**KIRKLEES METROPOLITAN COUNCIL
INVESTMENT & REGENERATION SERVICE**

**DELEGATED DECISION TO DETERMINE PLANNING APPLICATIONS TO
CARRY OUT DEVELOPMENT WITHOUT COMPLIANCE WITH PLANNING
CONDITIONS PREVIOUSLY ATTACHED**

Reference No:	2024/70/91008/E
Site Address:	adj, 115, Westfield Lane, Wyke, BD12 9LY
Description:	Variation of conditions 1 (plans) and 3 (landscape) of previous reserved matters approval 2023/90909 pursuant to outline permission 2020/90436 for demolition of 1 dwelling and erection of residential development and associated works with details for access
Recommending Officer:	Ellie Thornhill

Westfield Lane, Wyke
SITE PLAN AND LOCATION PLAN

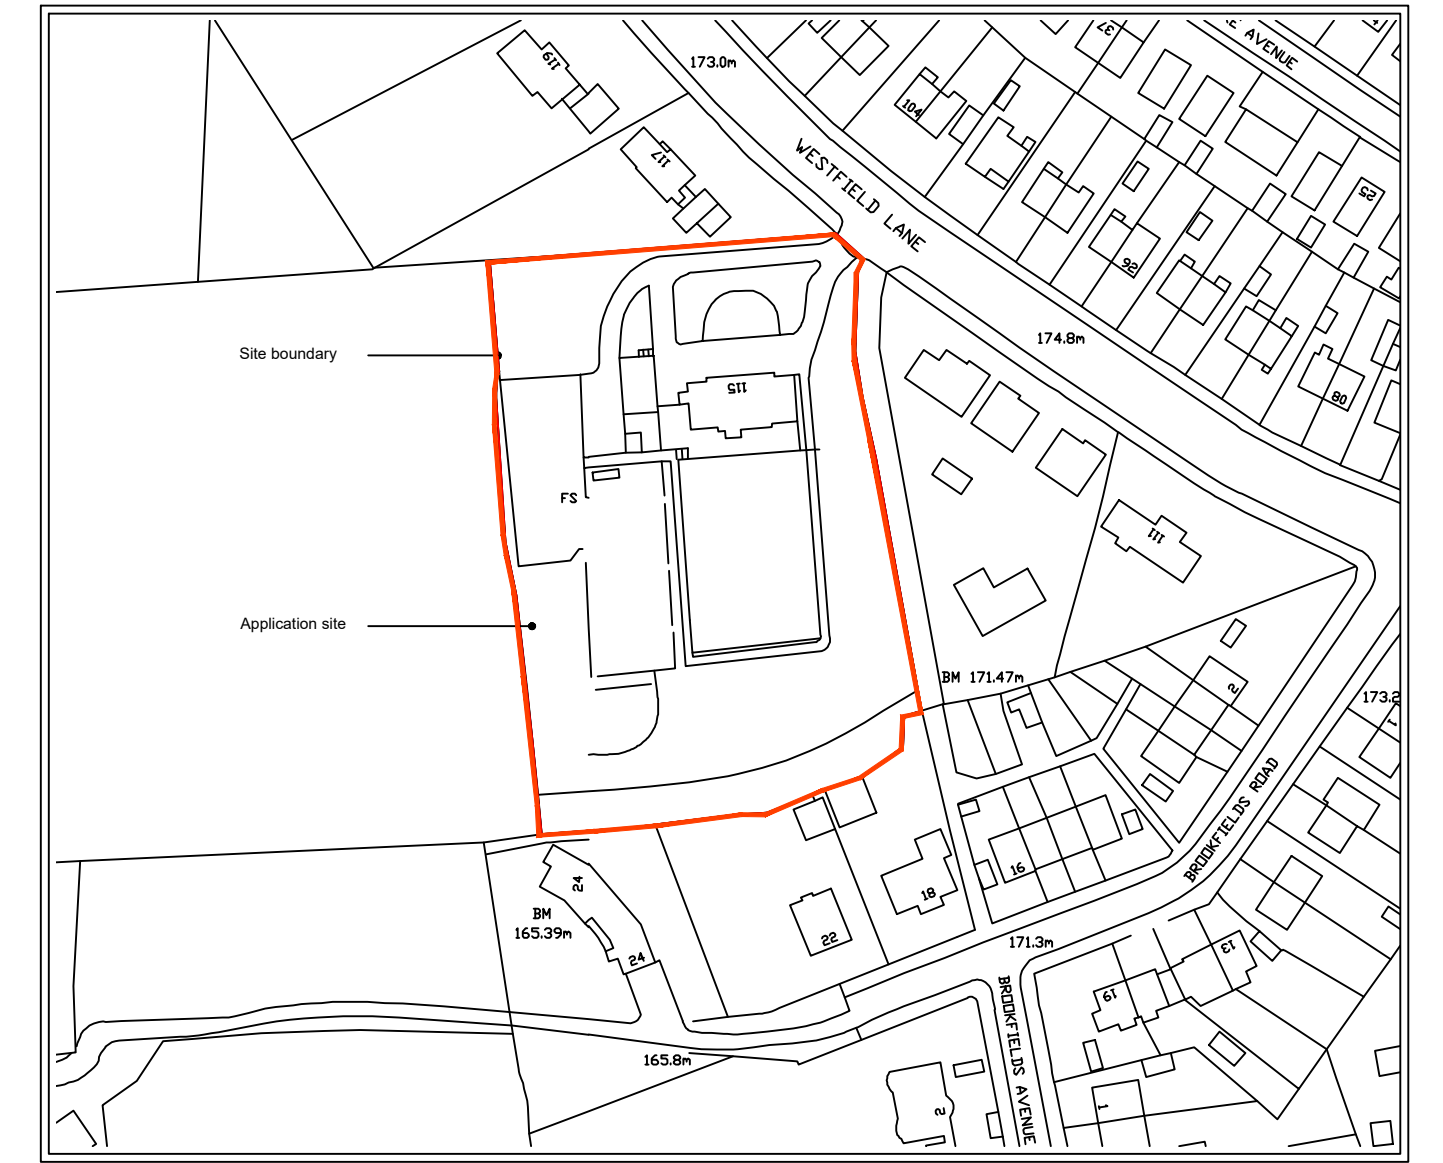
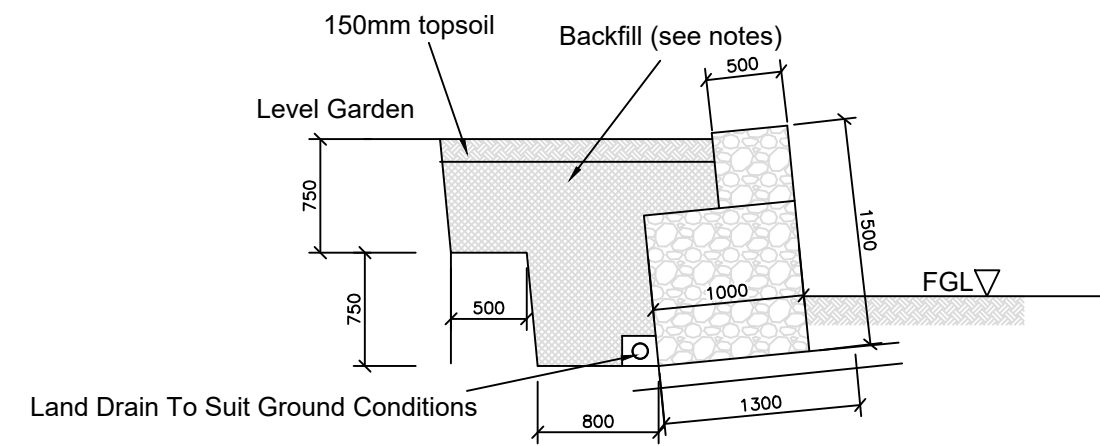
In this case, the variation seeks to amend the approved site layout to allow for an extension to the retaining wall around the side of plot 11, due to the additional stability works required. The wall would extend 19.5m, with the height ranging between 2.1m to 3.2m. Additional landscaping is proposed adjacent to the retaining wall to help avoid a stark finish. This would include planting native shrubs as shown on the landscape masterplan ref: R/2679/1L.

This application also seeks to gain permission for the slight re-location of the western gabion retaining wall which appears to have been built slightly further in from the site's red line boundary, as opposed to along it. The height of the wall would vary due to land levels from 2.5m to 3.1m. A 2.1m vertical timber fence is also proposed along the top of the retaining wall. Whilst officers would wish to see the retaining wall lower along this elevation, the changing land levels and requirement to ensure that the land is structurally stable for the houses above it, on balance this proposed structure can be supported. The gabion wall has been constructed from stone which is a sensitive material for this edge of countryside location.

Along with the above, the application site red line boundary to the southeastern corner of the site has also been reduced slightly to form more of a right angle. This is to accord with private rights of access. The change to plan would mean that the 2.8m right of access would sit closer to the adjacent trees. This will be considered in more detail within the report below.

In summary, given the landscaping proposed and the stability reasons behind the height of the retaining wall, on balance the proposal can be supported in relation to visual impacts.

In conclusion, the changes to the scheme are considered to be acceptable and would accord with Policy LP24 of the KLP, Chapter 12 of the NPPF and the aims of the adopted Housebuilders Design Guide SPD.
